DeLUCA-HOFFMAN ASSOCIATES, INC.
CONSULTING ENGINEERS

MEMORANDUM

DATE: August 30, 2012

SUBJECT: Canal Plaza Hotel, Site Plan Review

C-202

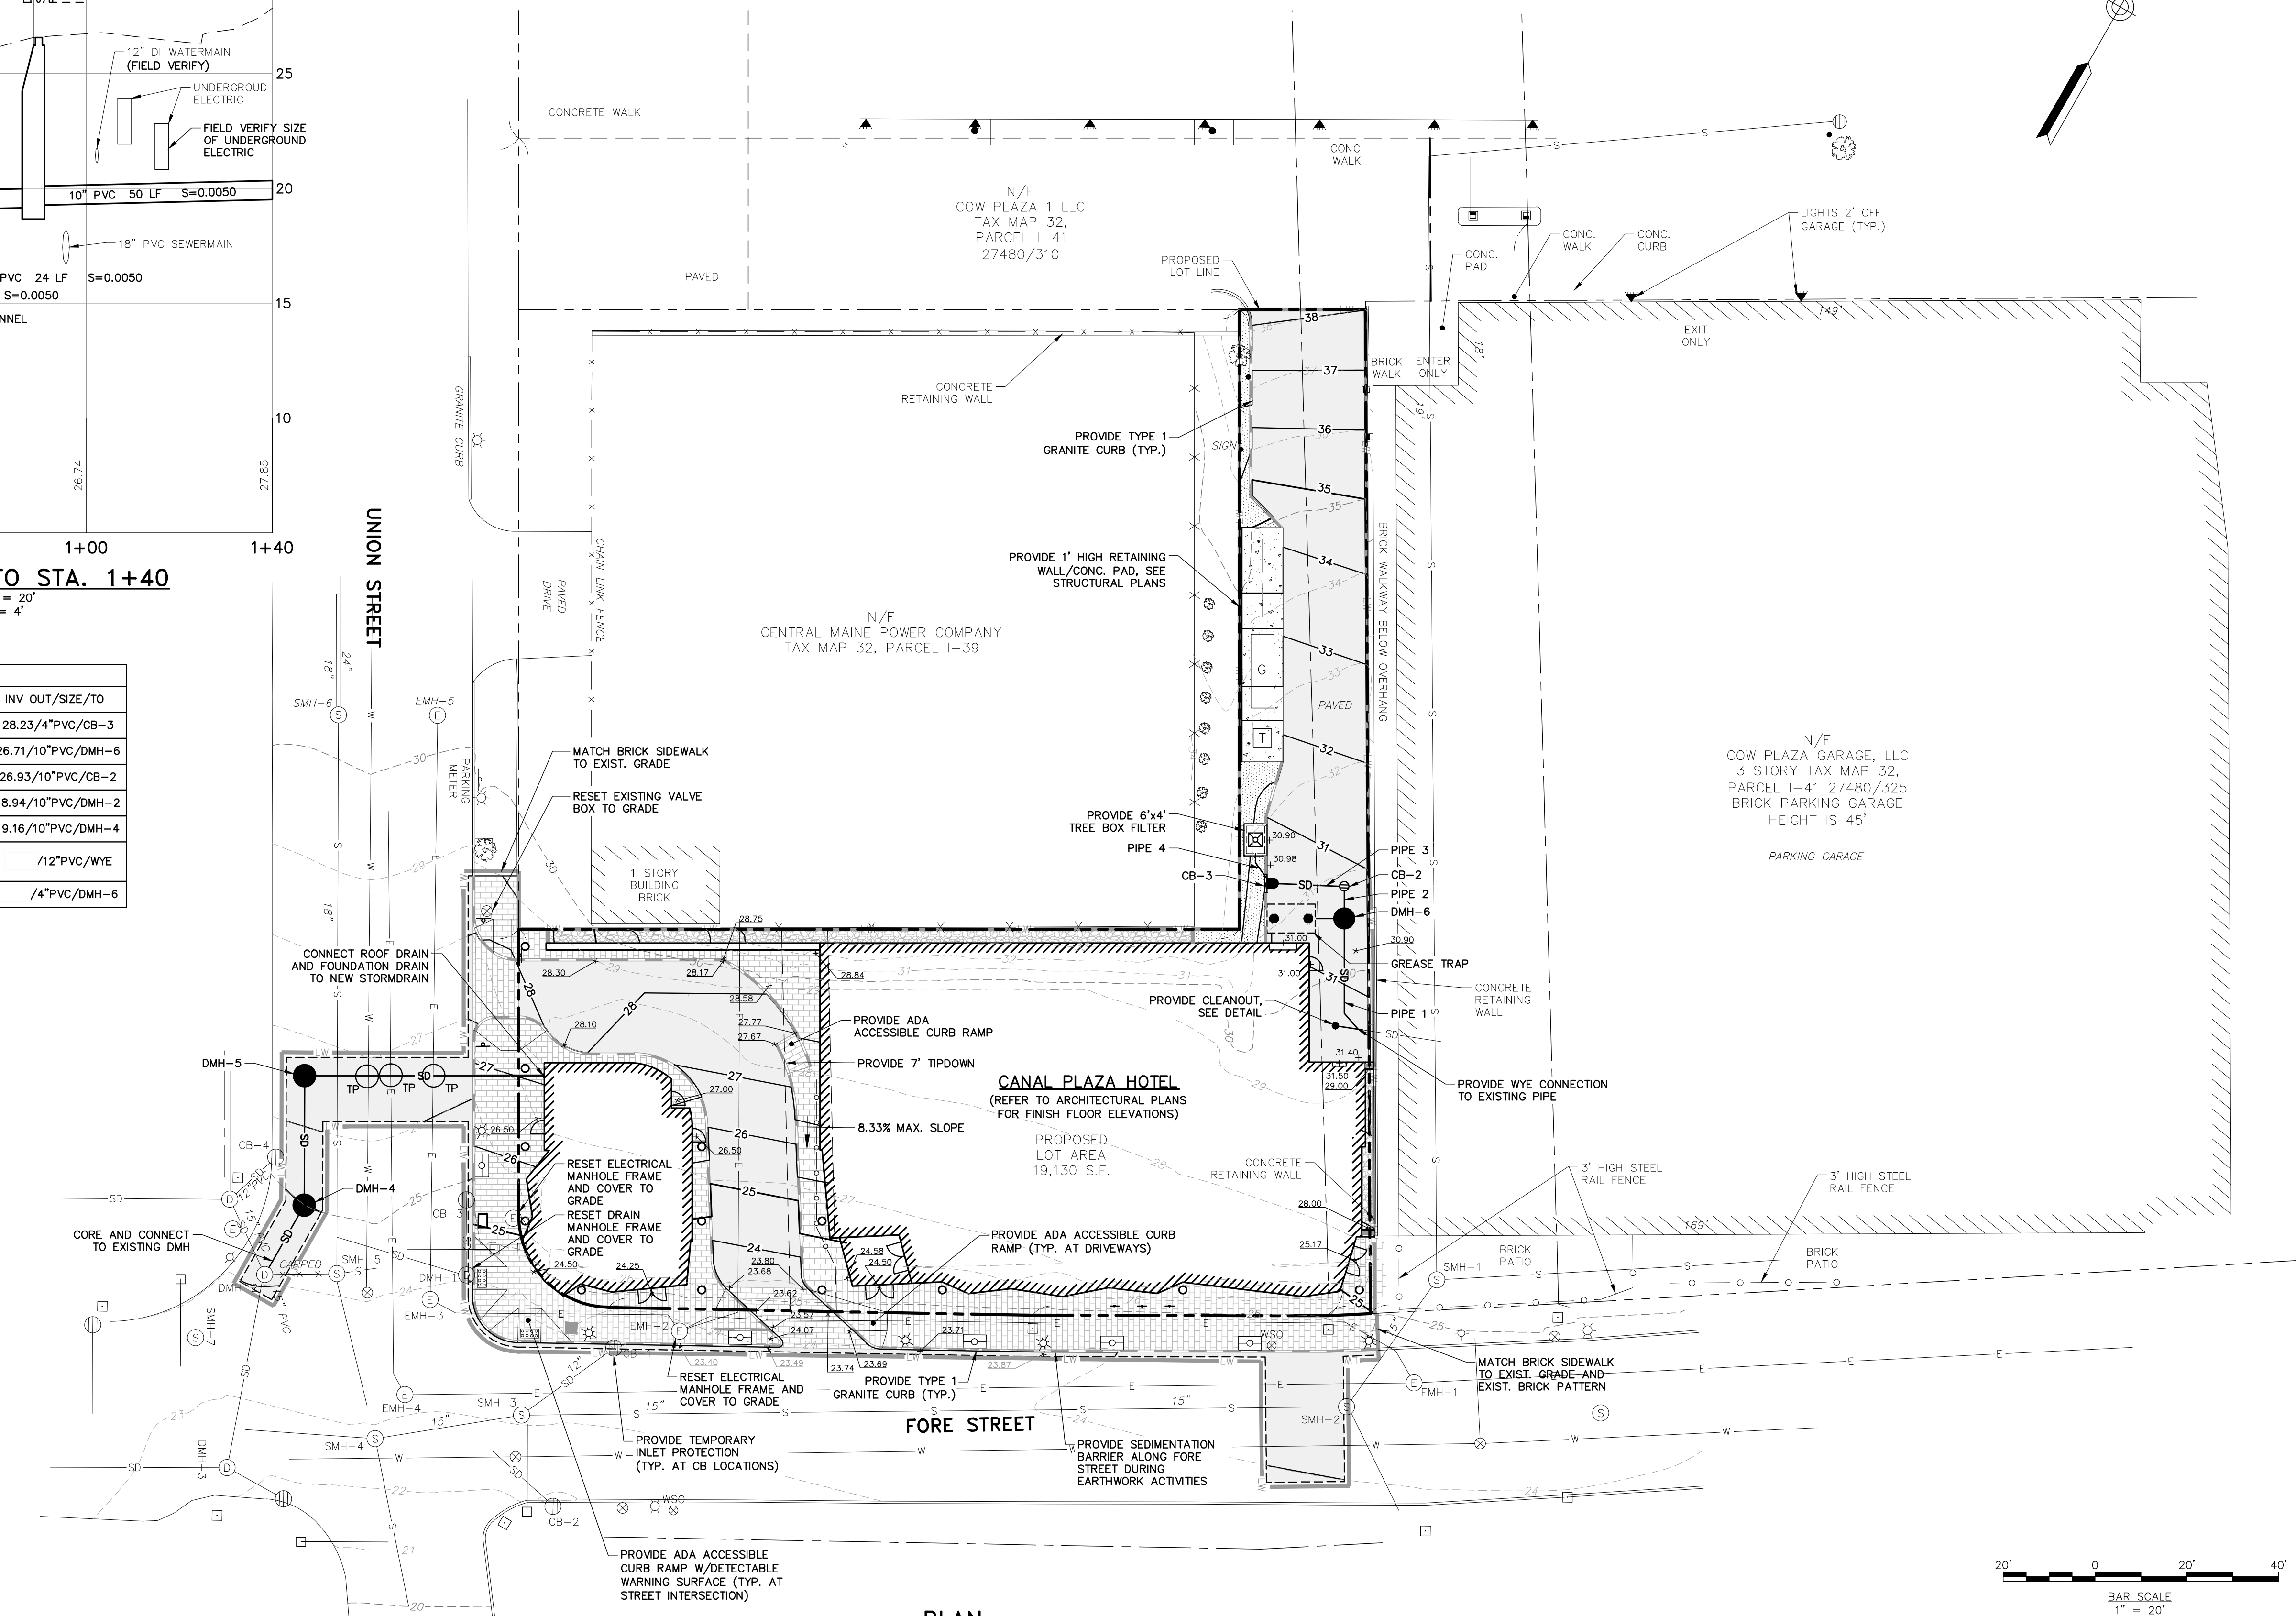
Sheet C-202 Grading, Drainage and Erosion Control Plan

1. Details pertaining to the tree box filter should be provided including sizing, plant material, piping, etc.
2. Roof drainage should be clearly identified and discussed as to connection points, etc. Although it may be that the roof drain ties into the storm drain extending into Union Street. We are uncertain of that at this point.
3. Design info for all proposed storm drainage and appurtenant structures will need to be indicated on the next round of drawings.
4. Information pertaining to retaining wall structures to the east side and north side of the site should be more clearly identified in the next round of drawings. Are there constructability issues due to the proximity of the property lines?
5. Spot grades at entrance locations and along the sidewalks would be beneficial and are recommended.

UTILITY PLAN

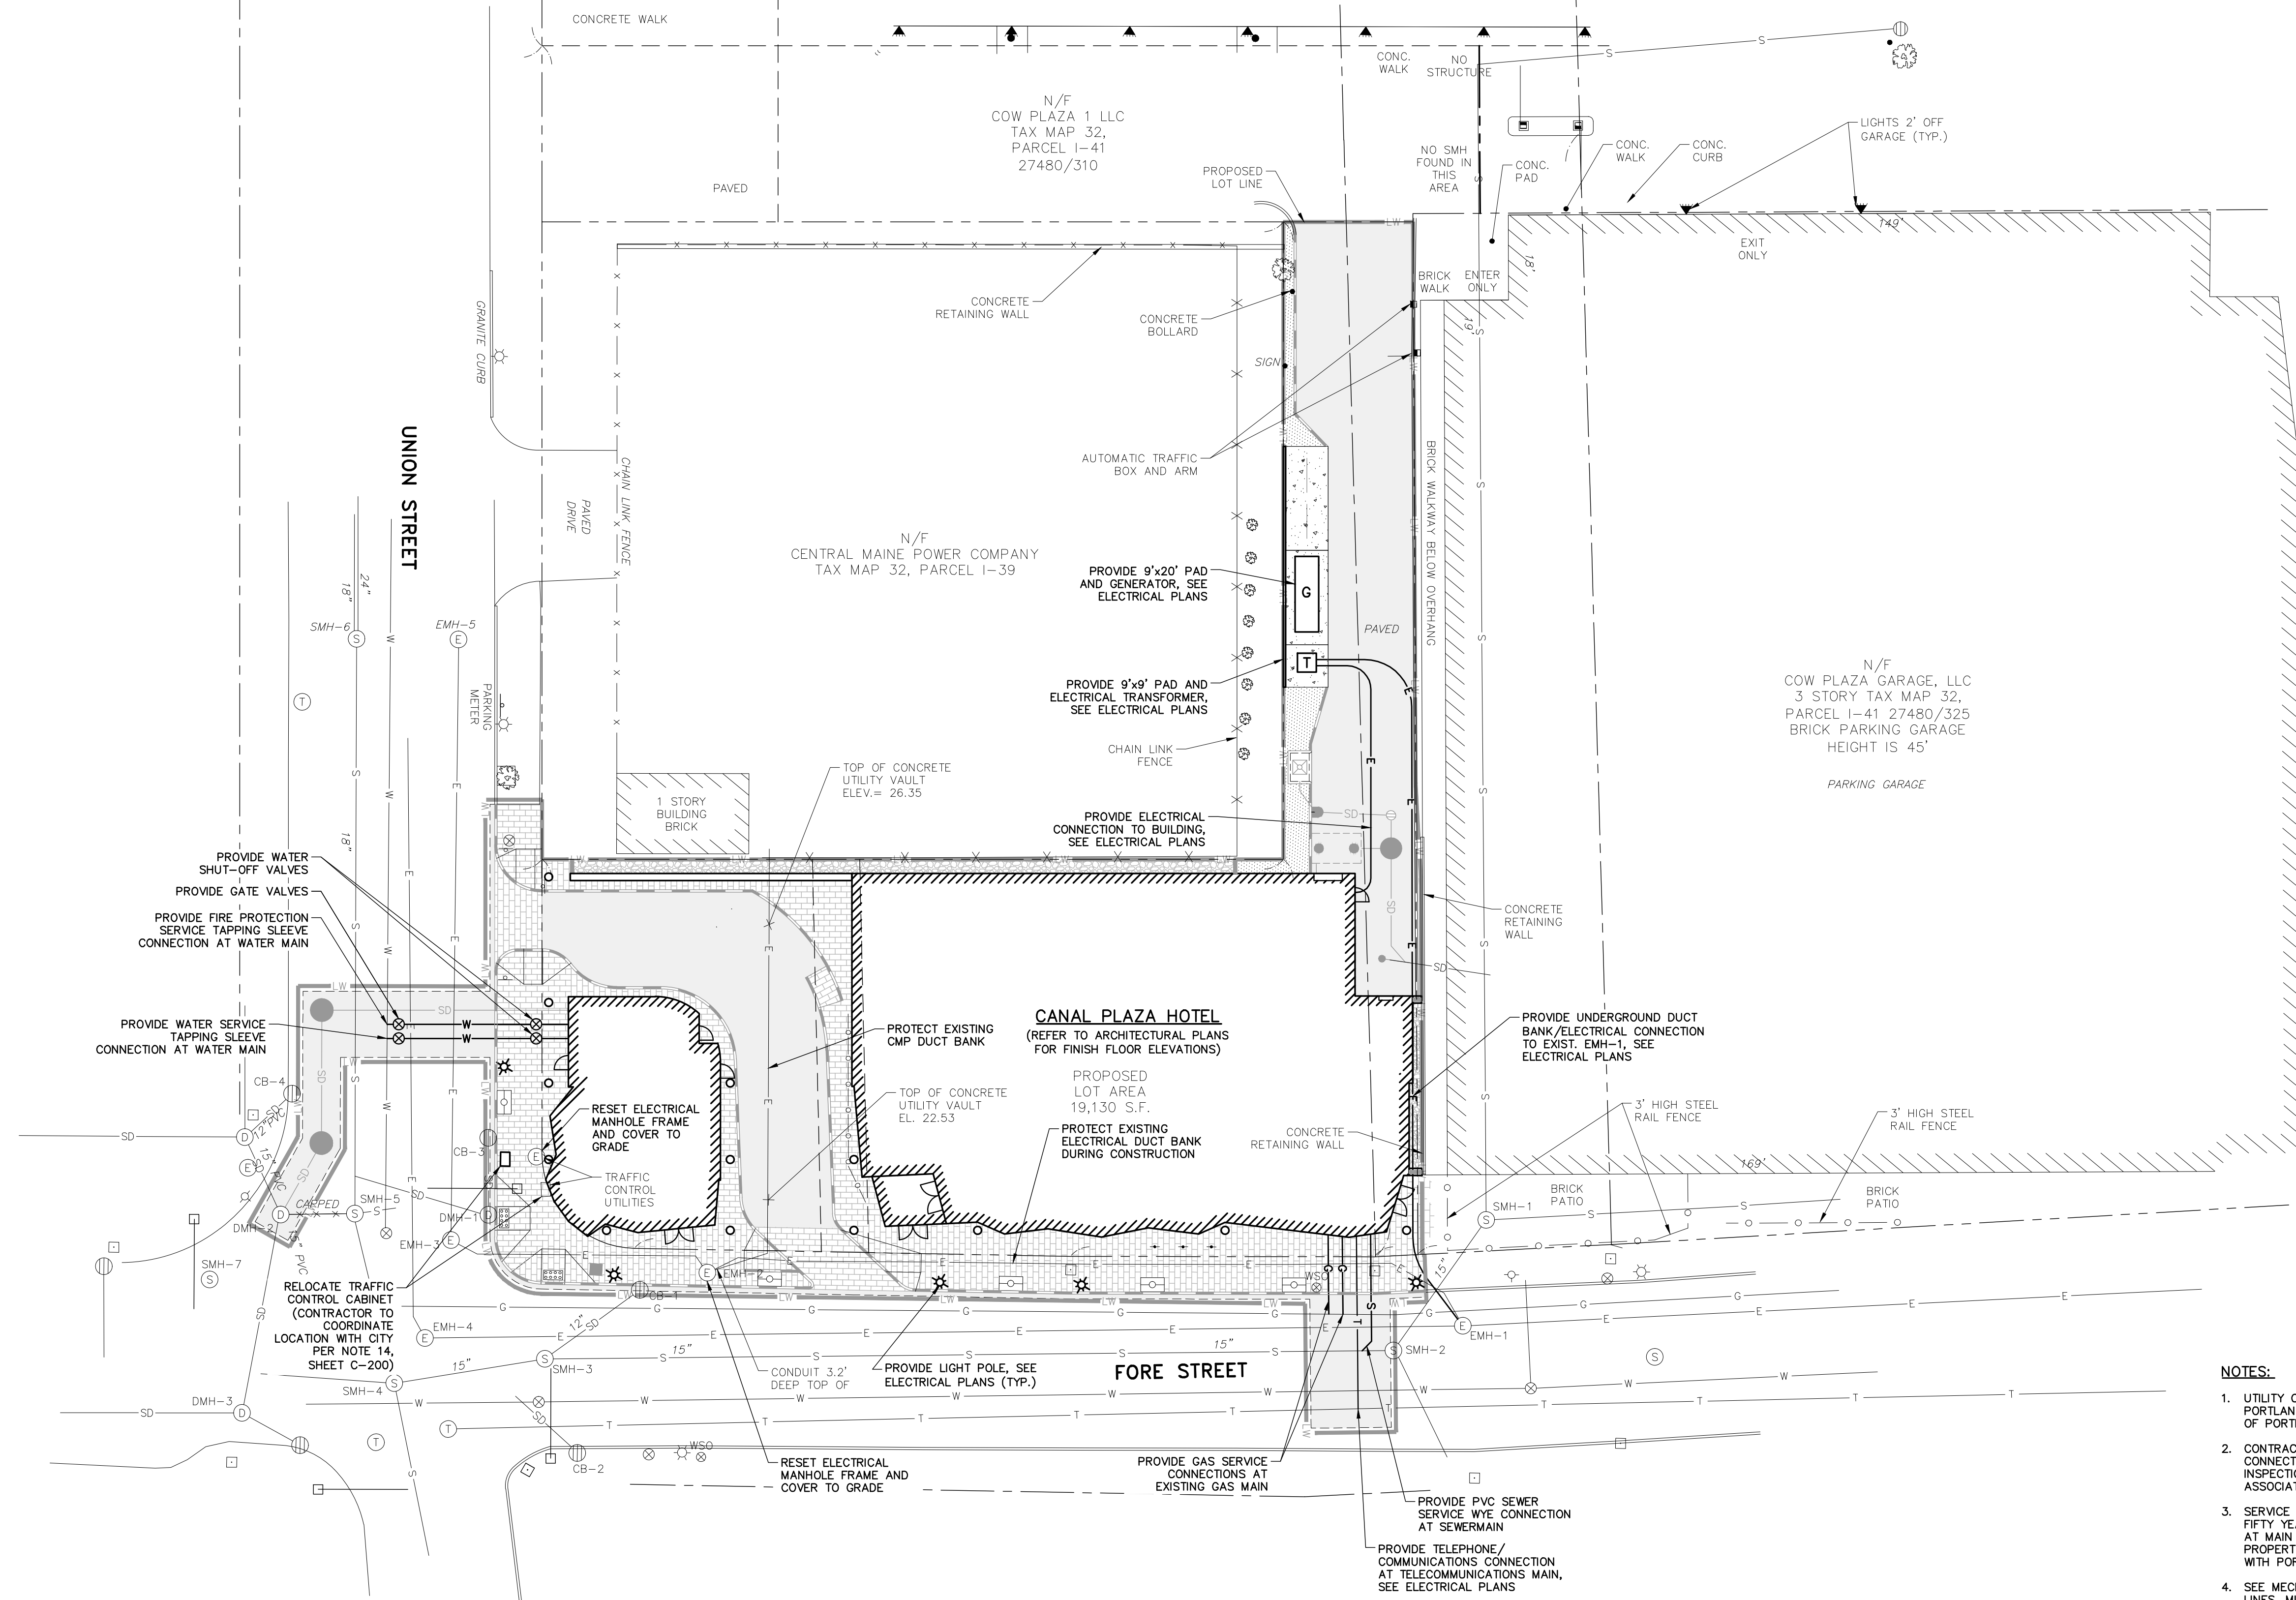
Sheet C-203 Utility Plan

1. Applicant's engineer should review pipe systems in Union Street with respect to storm drainage and water and conflicts with existing utilities running up and down Union Street. Profiles and/or test pits might be beneficial.
2. The engineer should confirm CMP setback requirements and sizing again for the transformer pad. Will an emergency generator be necessary, and if so, where will it be located?
3. Has CMP reviewed, and have they accepted, the location of the underground primary power supply along the easterly side of the building? If so they should be shown on the plans.
4. It is unclear if the utilities are to be shared between the two buildings. If so, will these utility lines go underground beneath the entrance driveway?
5. The fire department connection(s) should be identified as to where they will be.

6. We assume site lighting information will be provided within another round of information.
7. We note the lowering of ground grades above the existing CMP duct bank and wonder if test pits are necessary to confirm depth of that existing piece of infrastructure and will the lowering of grade over it negatively impact it.
